From: Kate Giddings <kate.giddings@arun.gov.uk>
Sent: 25 February 2022 11:42
To: Simon Davis <Simon.Davis@arun.gov.uk>
Cc: Planning.Responses <Planning.Responses@arun.gov.uk>
Subject: P/15/22/DOC - land rear of Sefter School House, Sefter Road, Pagham

In relation to the above DoC application, Environmental Health would please like to comment as follows:

Dwg Ref : CMP-01A

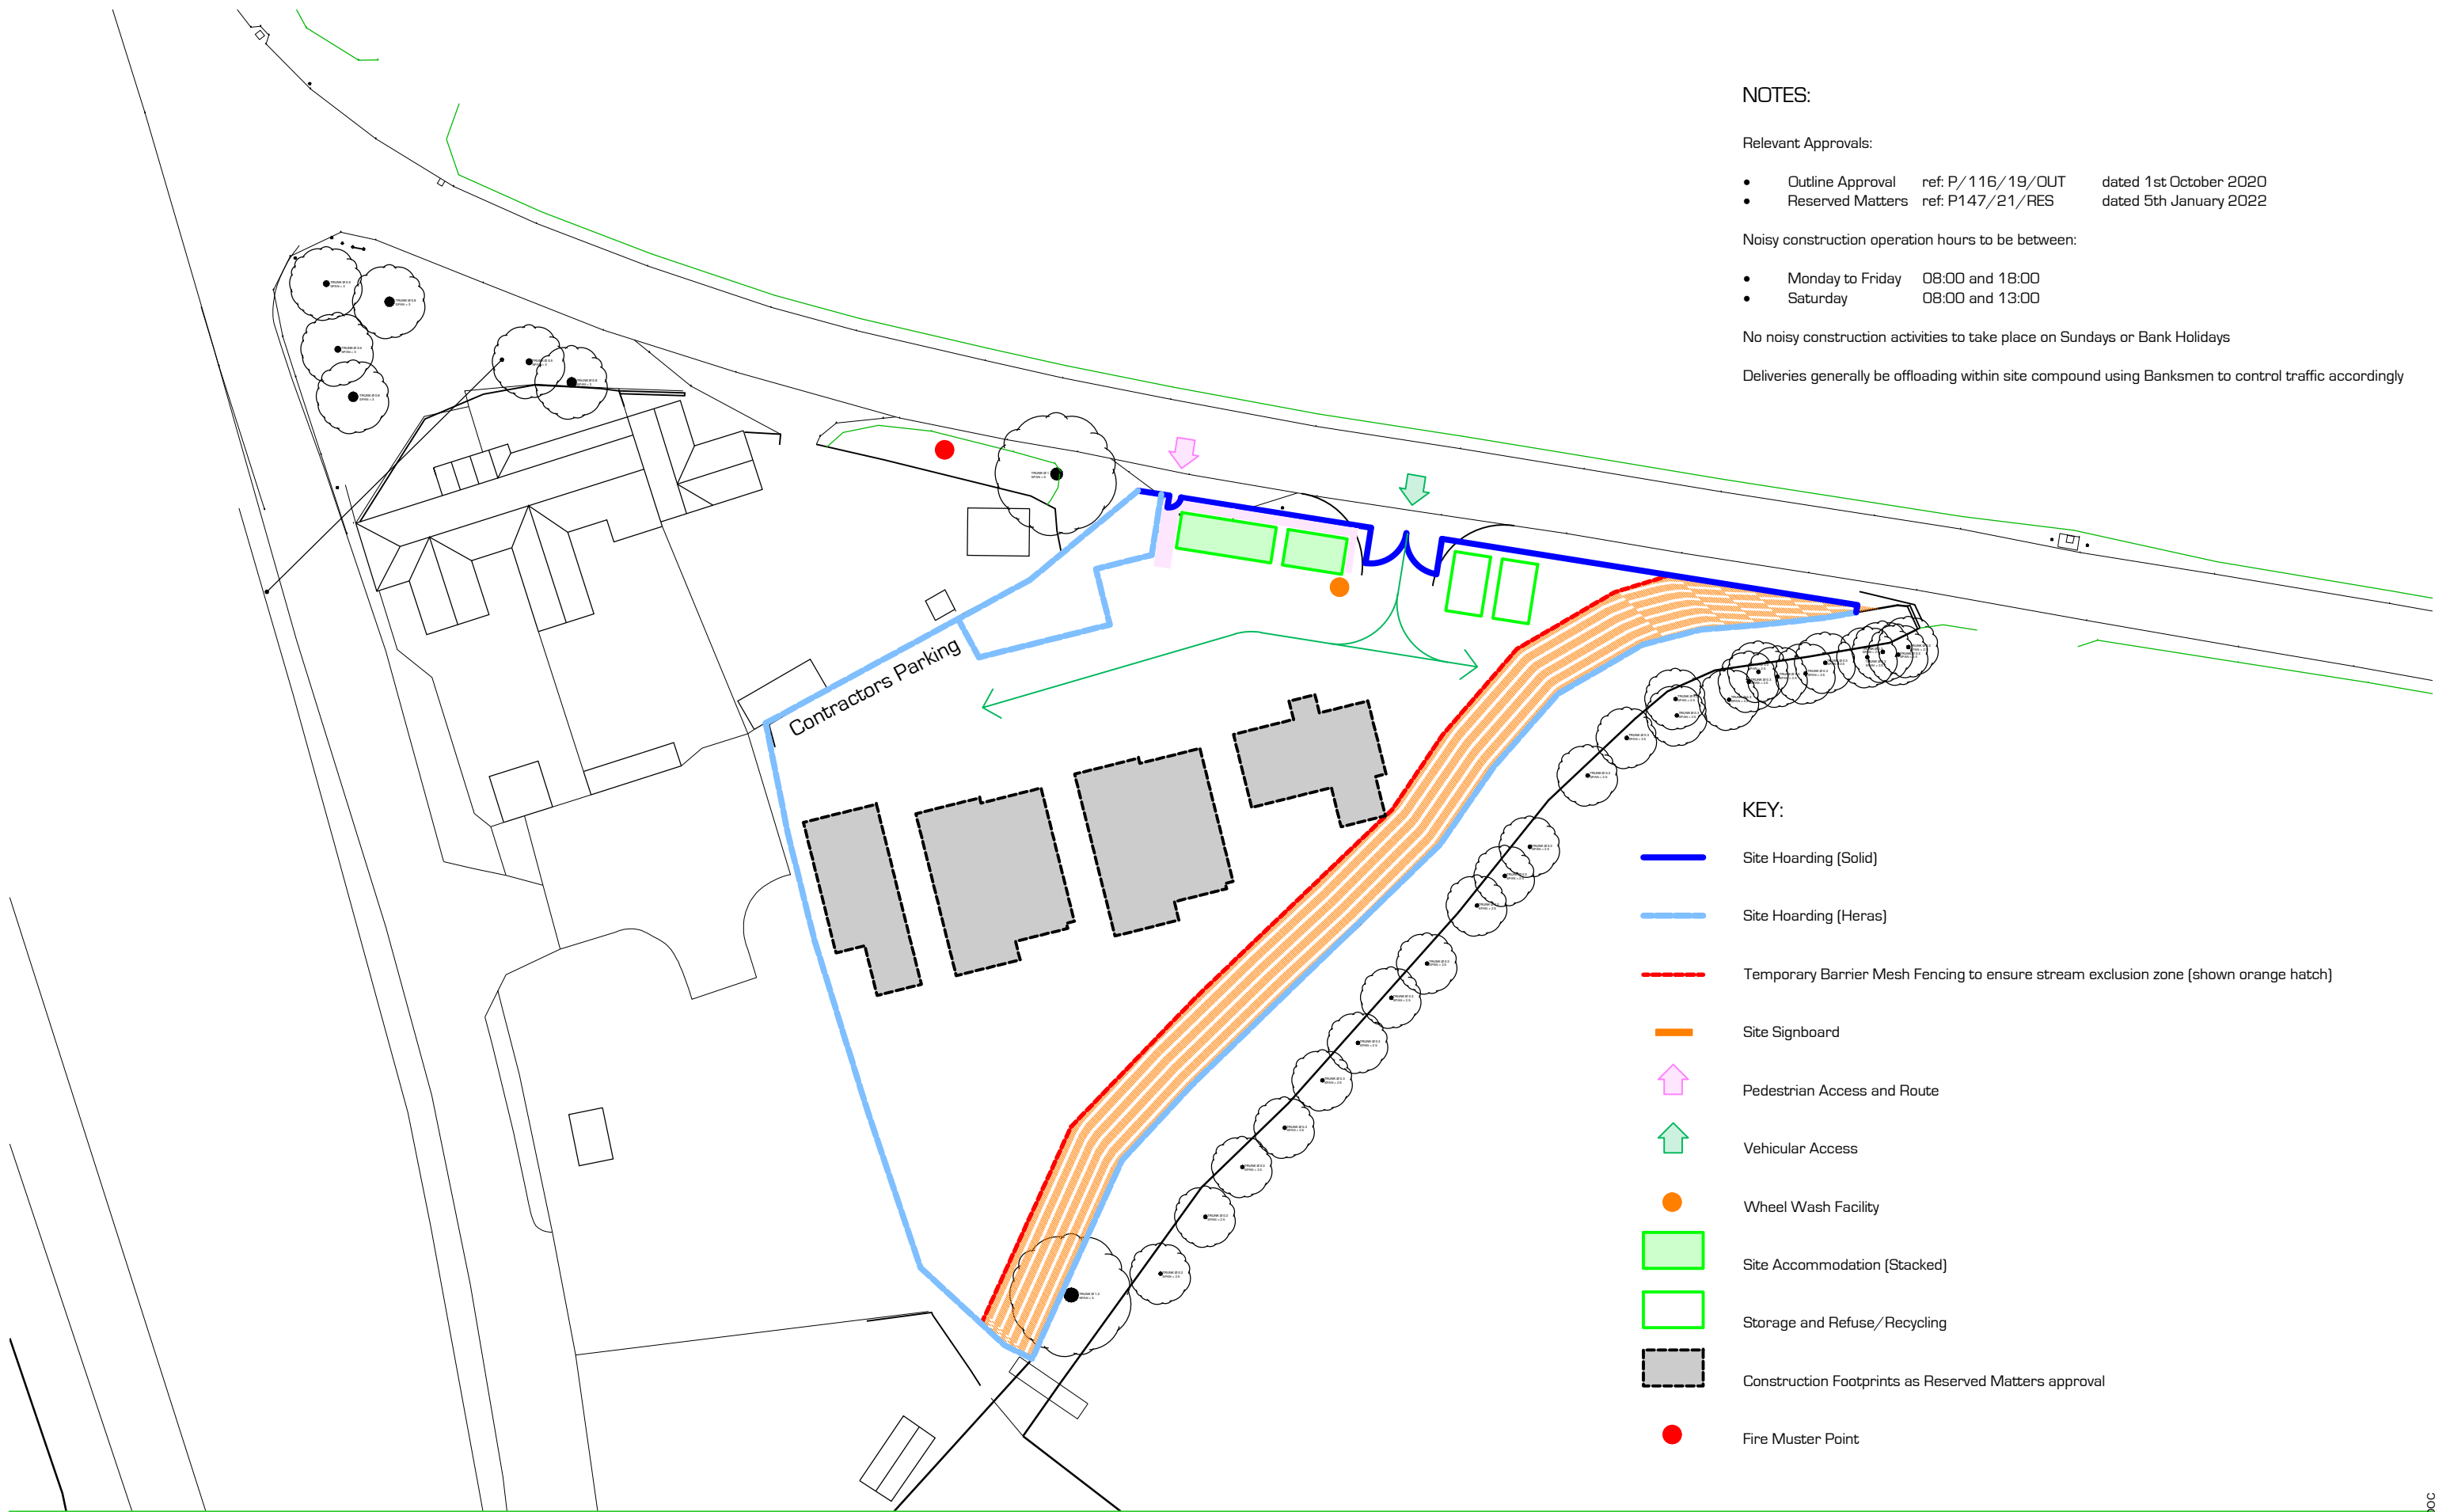
The submission provided (Dwg no. CMP-01A, dated January 2022) does not suitably address the requirements as outlined in the condition, therefore this Department cannot recommend discharge.
